Recommendation Report for Planning Permission for Works or Extension to a Dwelling

REF NO: BE/25/26/HH

LOCATION: 86 Addison Way
Bersted
PO22 9HZ

PROPOSAL: Part two-storey front extension to create larger third bedroom and utility space.

PROJECT	86 Addison Way PO22 9HZ		CLIENT Edwards	
	SHEET Elevations-Right/Left side	Date	Issue Date	Scale (@ A3) 1 : 100
		Drawn by SW	DRAWING NUMBER P 4	REV
		Checked by SR

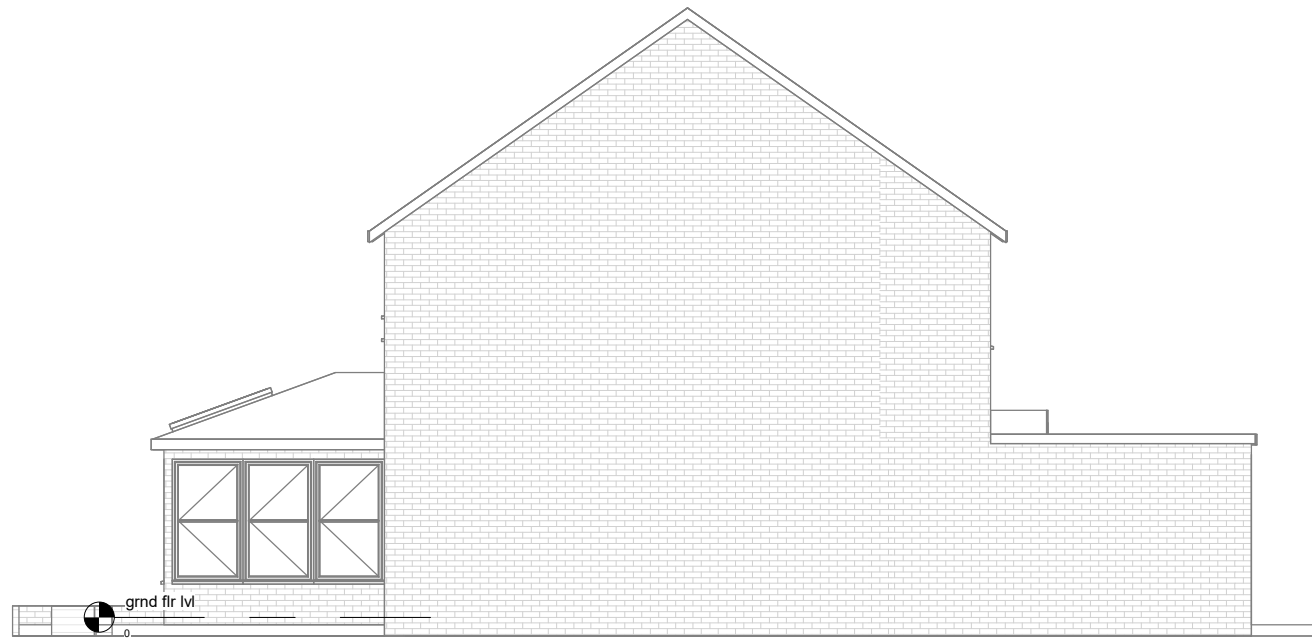
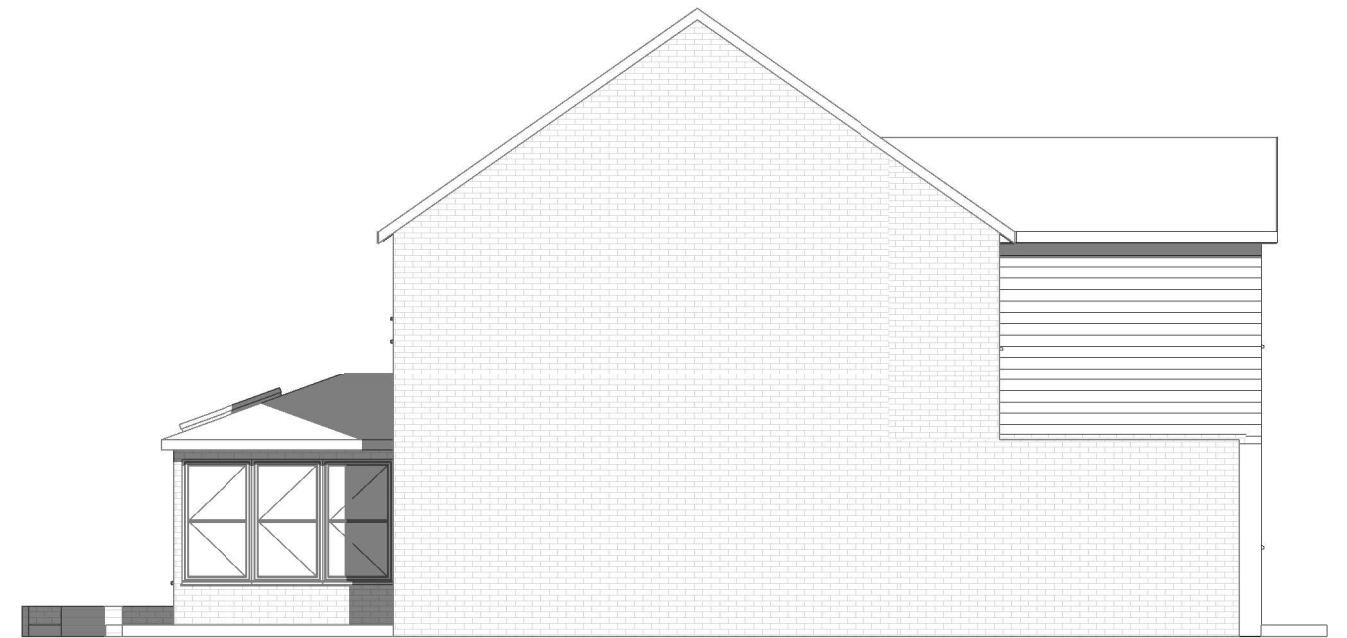
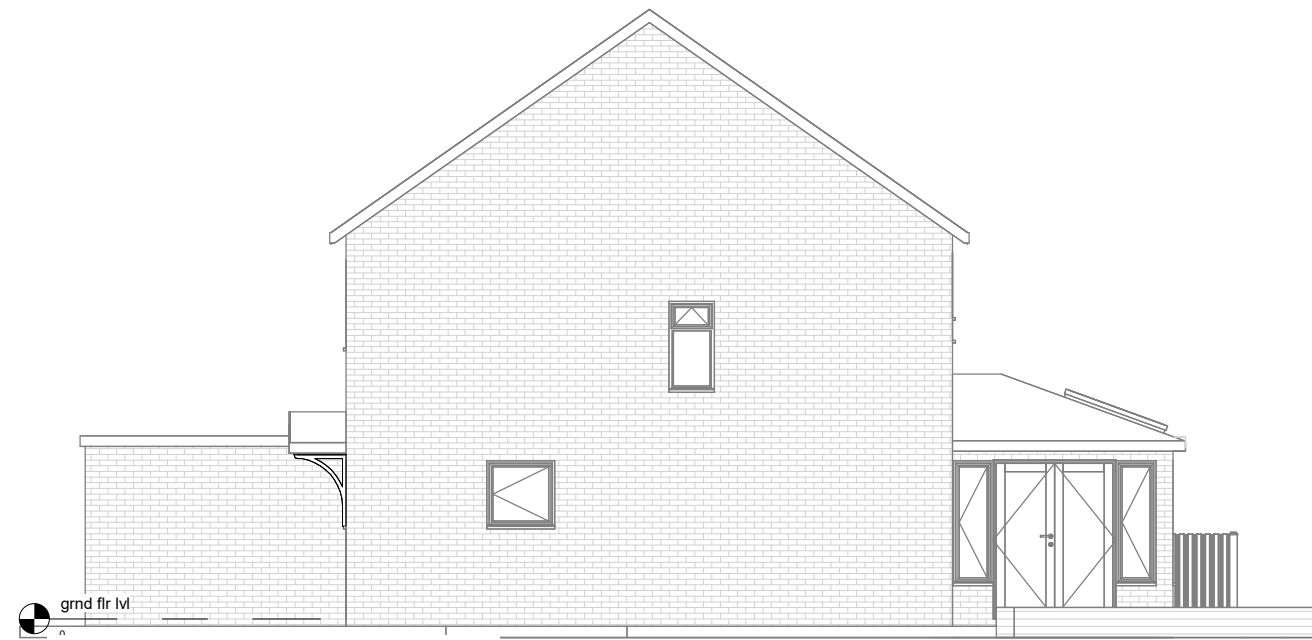
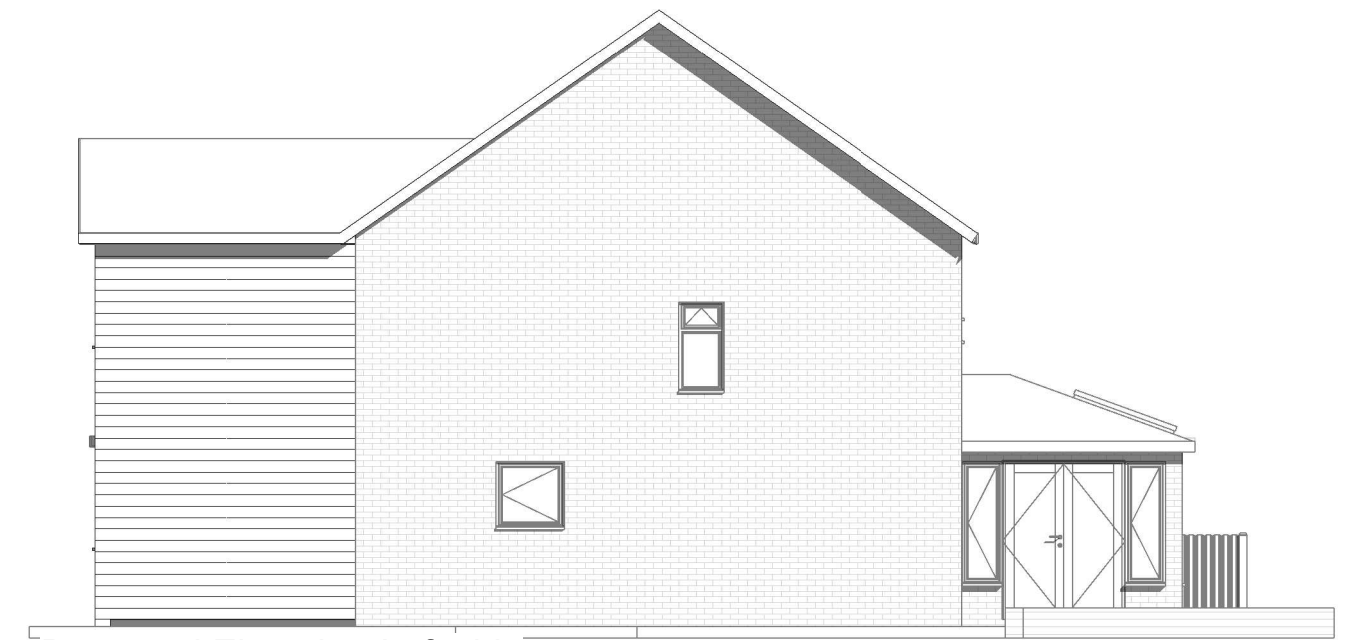
The proposed two-storey extension would be sited to the southern aspect of the front elevation, infilling the recessed area between the front garage projection and the main two storey front elevation. The proposal would have a depth of 3.5m and a width of 2.8m. The pitched roof would have a height of 6.5m and an eaves height of 5m with the gable end fronting the street scene.

The proposed two-storey front extension would be finished in light grey cladding, extending across the front and side elevations, whilst the remaining front elevation of the dwelling would retain its existing brick finish. Although the proposed light grey cladding is not currently characteristic of the host dwelling, it would not appear unduly prominent or incongruous within the street scene. This is particularly given the presence of the neighbouring property at No. 87 Addison Way, which features white cladding to its front-facing gable. As such, the proposal would reflect the established character and appearance of the surrounding area and would integrate appropriately within its context. The development is therefore acceptable in accordance with ALP policies D DM1 and D DM4 and the ADG.

The proposed two-storey front extension would be set back from the front (west) boundary by 6.4m and set in from the side (south) boundary 1.4m. This would not comply with the minimum guidance of 2m for a first-floor extensions outlined in the ADG policy M. Given the existing similar side boundary separation with the neighbouring property (south), and that the two storey extension would not extend beyond the existing flank elevations of the host dwelling, the spacing maintained between the proposed first-floor side extension and the neighbouring property would not result in harm to the overshadowing or overbearing impacts.

PROJECT	86 Addison Way PO22 9HZ		CLIENT Edwards	
	SHEET First Floor	Date	Issue Date	Scale (@ A3) 1 : 100
		Drawn by	SW	DRAWING NUMBER
		Checked by	SR	P 2

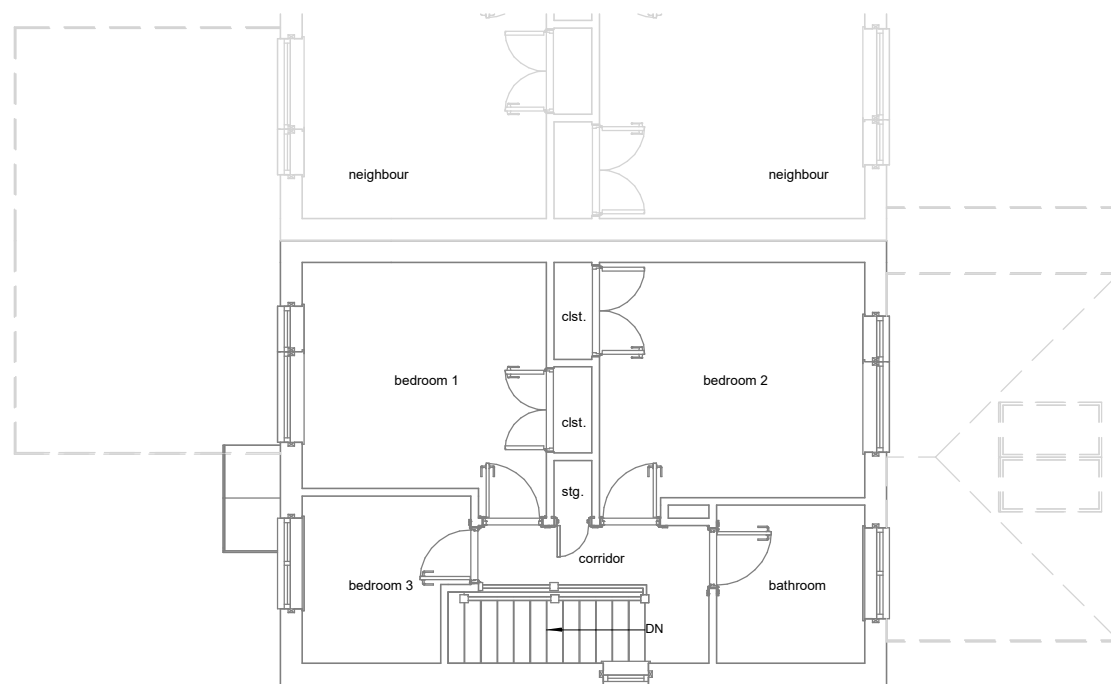
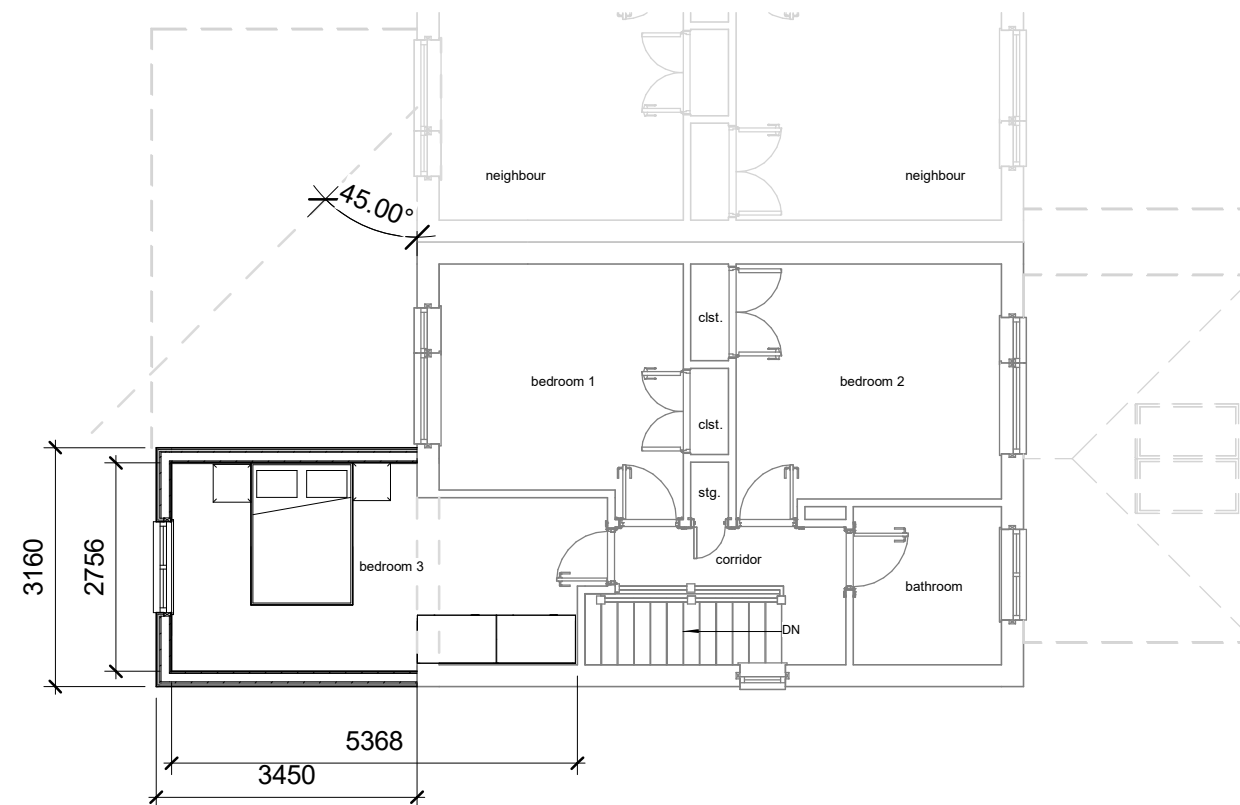
The fenestration proposed to the front (west) elevation of the two-storey front extension would have an outlook of the front amenity serving the host dwelling and would not give rise to any overlooking.
